Ribble Valley Borough Council
Council Offices
Church Walk,
Clitheroe
Lancashire
BB7 2RA

Phone: 0300 123 6780
Email: developeras@lancashire.gov.uk
Your ref: 3/2025/0346
Our ref: 3/2025/0346/HDC/KW
Date: 17 June 2025

Location: Dowsons Dairies Ltd Hawkshaw Farm Longsight Road Clayton le Dale
BB2 7JA
Proposal: Change of use of agricultural land to create an additional 95 car parking
spaces.
Grid Ref: 365633 432313

| Proposed Site Layout Plan | | Dwng No. | Rev. |

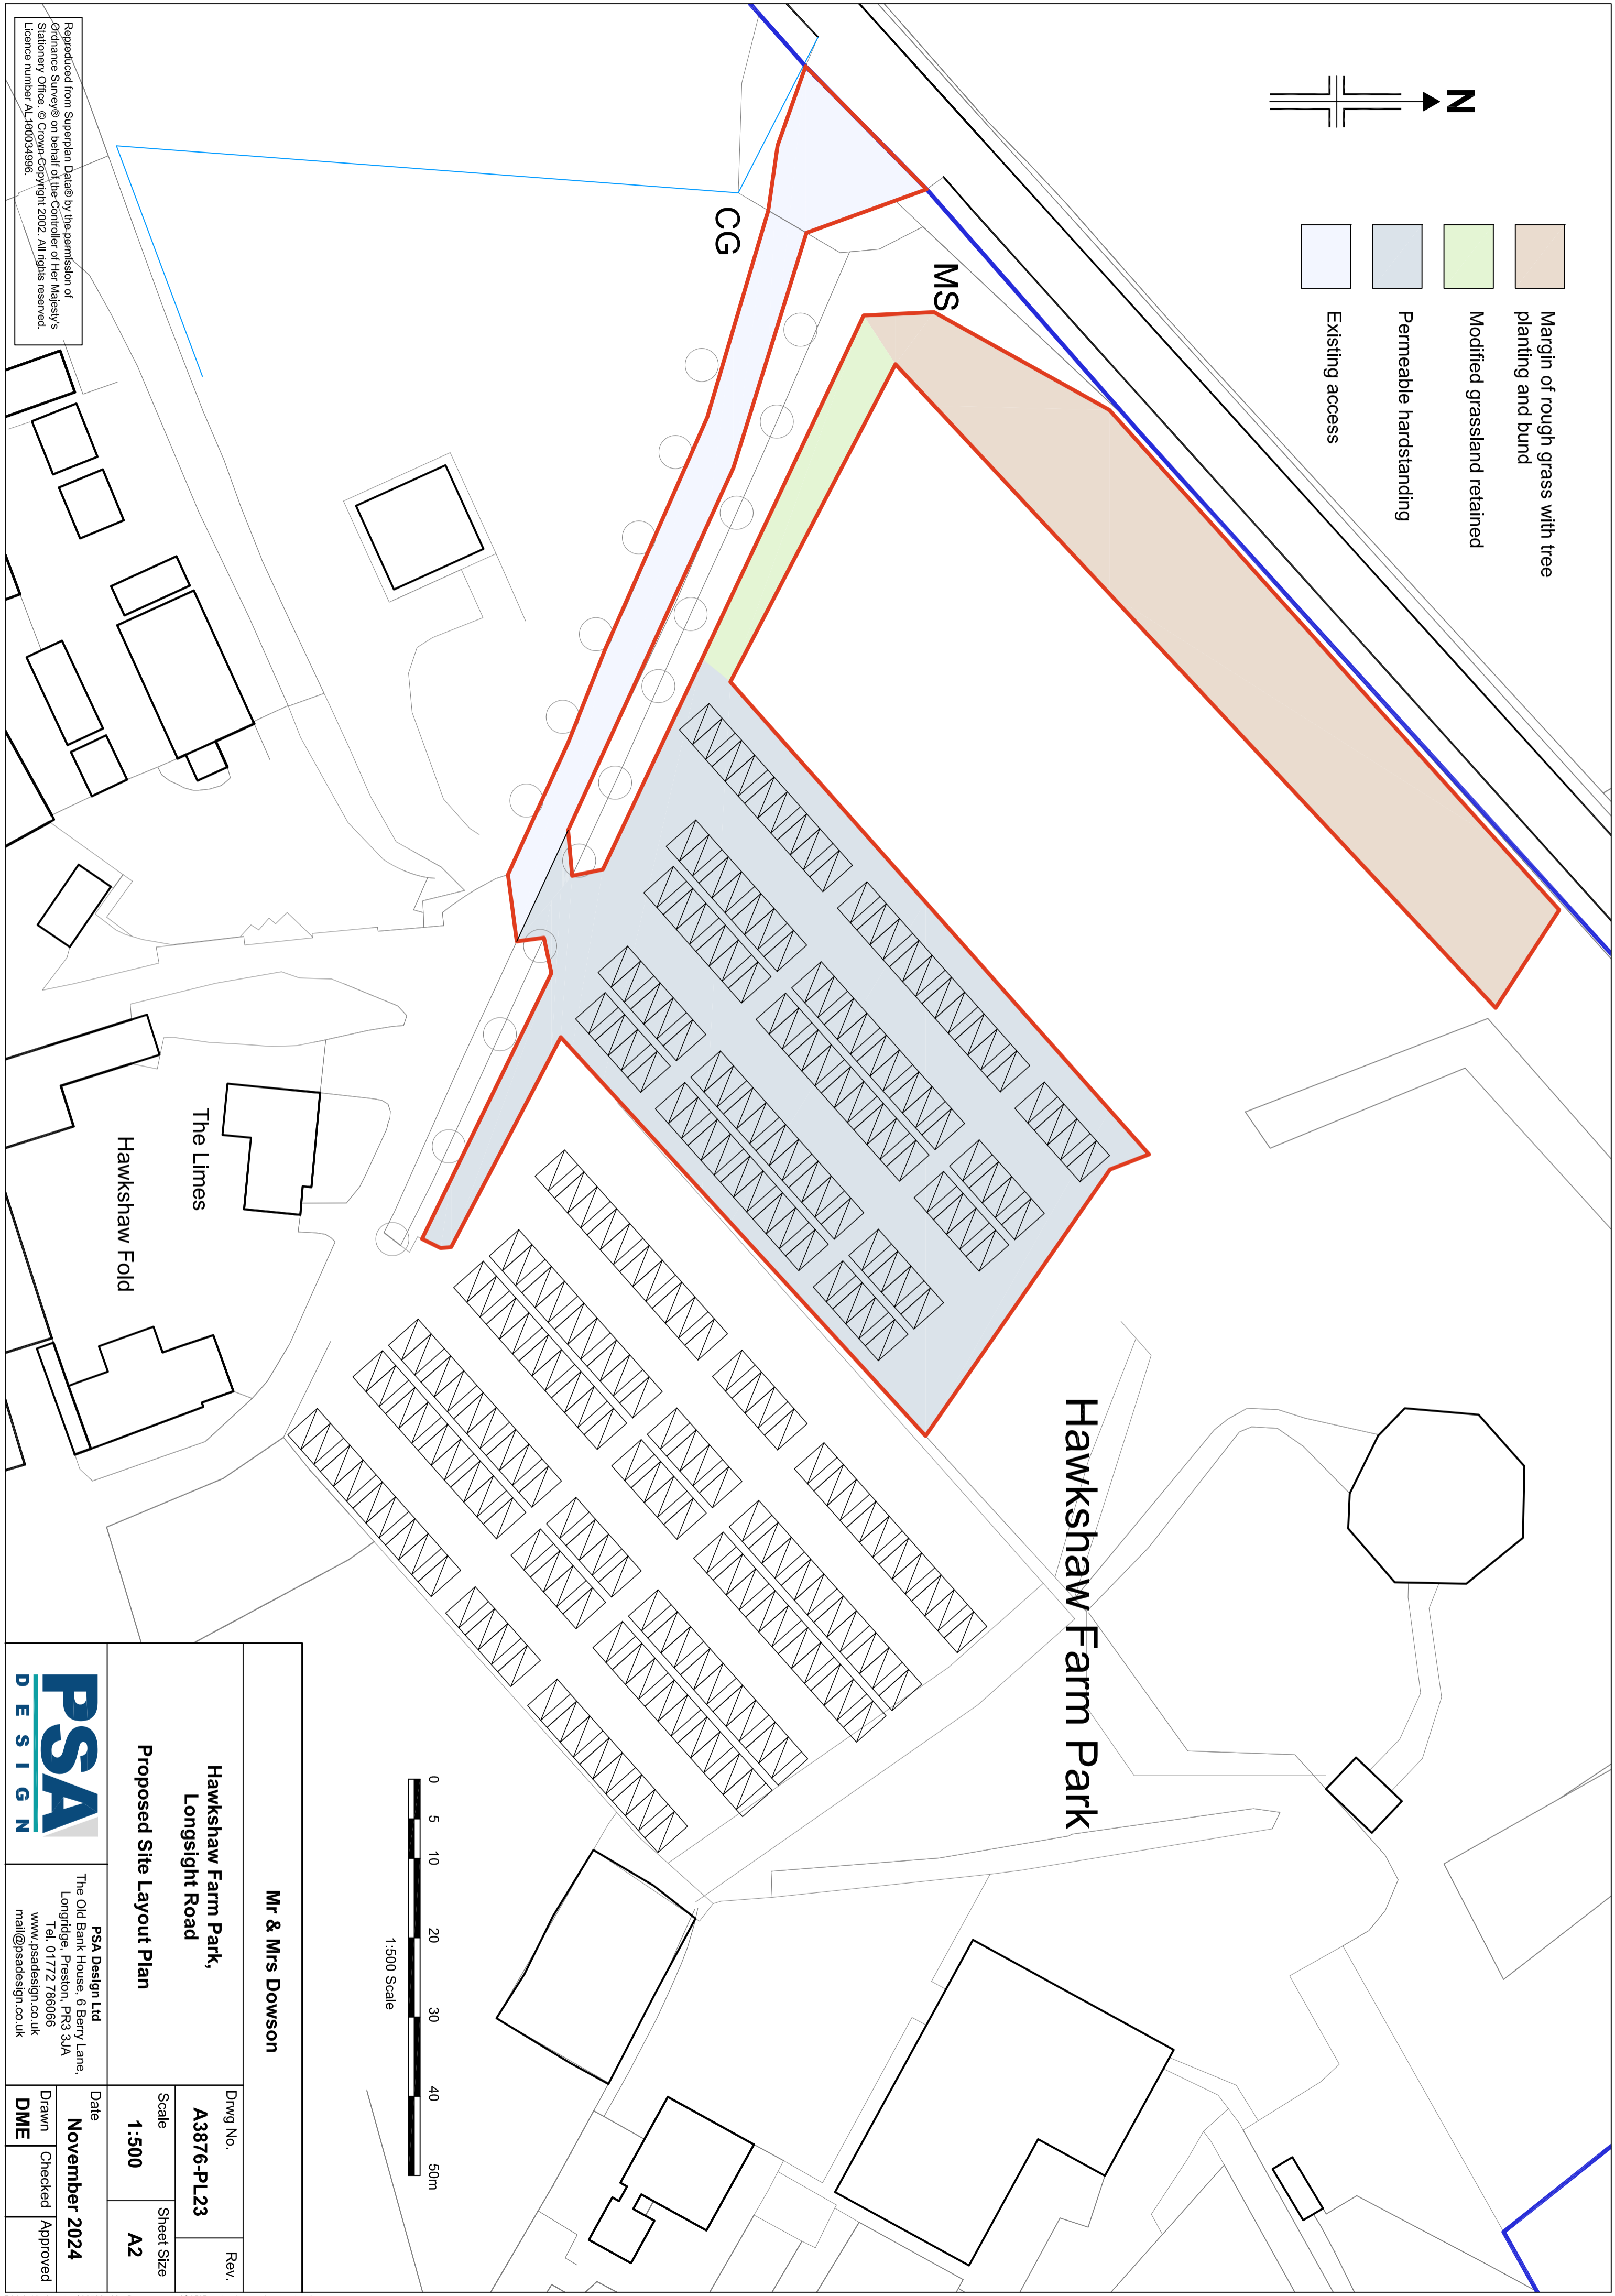
The LHA therefore see there is a need for parent and children bays or standard parking bays that have additional spacing which is suggested as part of the proposal. The LHA would recommend that the parent and child parking spaces provide a width of 3.2 metres for added convenience, or as suggested within the plans, a minimum zone of 1.2 metres adjacent to the bays will provide additional door opening space.

Given the concerns regarding inconsistent parking gaps from visitors at the site to cater for a larger door opening space, the proposed parking facilities would benefit from formalised marked bays in order to achieve the maximum possible parking provisions for the site and reduce the risk of vehicles parking in an uncoordinated manner as previously seen. Whilst the surfacing is unlikely to support the use of long term road markings, other measures such as block edging on the corners of each space can be used to mark out the spaces. Upgrading the existing parking area with such edging would also help provide more efficient provisions.

However the LHA would like to highlight that the parking provisions which are adjacent to the existing car park are unlikely to be usable due to the width of carriageway fronting the spaces, it is not clear from the plan if the existing parking area is to be joined into the proposed car park or if the two will remain separate with fencing as such currently it would appear that there is a 2m gap between the far north east parking space and what appears to be a fence on drawing number A3876-PL25. The LHA would expect at least a 6m space adjacent to the parking areas to ensure vehicles have enough room to manoeuvre into and out of the spaces freely which would make the spaces practical. Clarification should be provided on if this can be achieved.

The design and access statement mentions that the applicant also wishes to improve traffic flow within the car park and is proposing to have a one way system in place, in order to ensure this is the most appropriate way to address congestion within the site, an amended plan should be provided showing the one way system route as well as signage which should be placed around the car park to ensure compliance.

The LHA note that two of the rows of parking spaces has a 1m gap running horizontally through the rows of parking spaces, as well as vertical rows which are a minimum of 2m in width, these gaps run through the proposed car park and through the existing car park leading to the site entrance. This provides direct pedestrian passage through the site, and would benefit from being a formalised pedestrian route to ensure it remains clear. Pedestrian facilities should be 2m wide in line with inclusive mobility guidance. A safe pedestrian route should be provided along the most direct route from the car park to the main entrance, which will improve pedestrian safety.

The application has also included their plans to divert a number of Public Rights of Way. The inclusion of a diversion A-X has raised concerns due to the proposal for the extension of the car park. The proposal to divert the Public Right of Way appears to conflict with proposed parking areas and as such the direct route is likely to be obstructed by parked vehicles.

To ensure the development aligns with best practices and planning requirements, the applicant should provide additional clarification and revised proposals addressing these issues. Specifically, details on how the first line of parking spaces adjacent to the existing car park will be accessed, the suitability of a one-way system, formalised pedestrian routes, and clarity on how the car parking provisions will be formalised to ensure parking compliance.
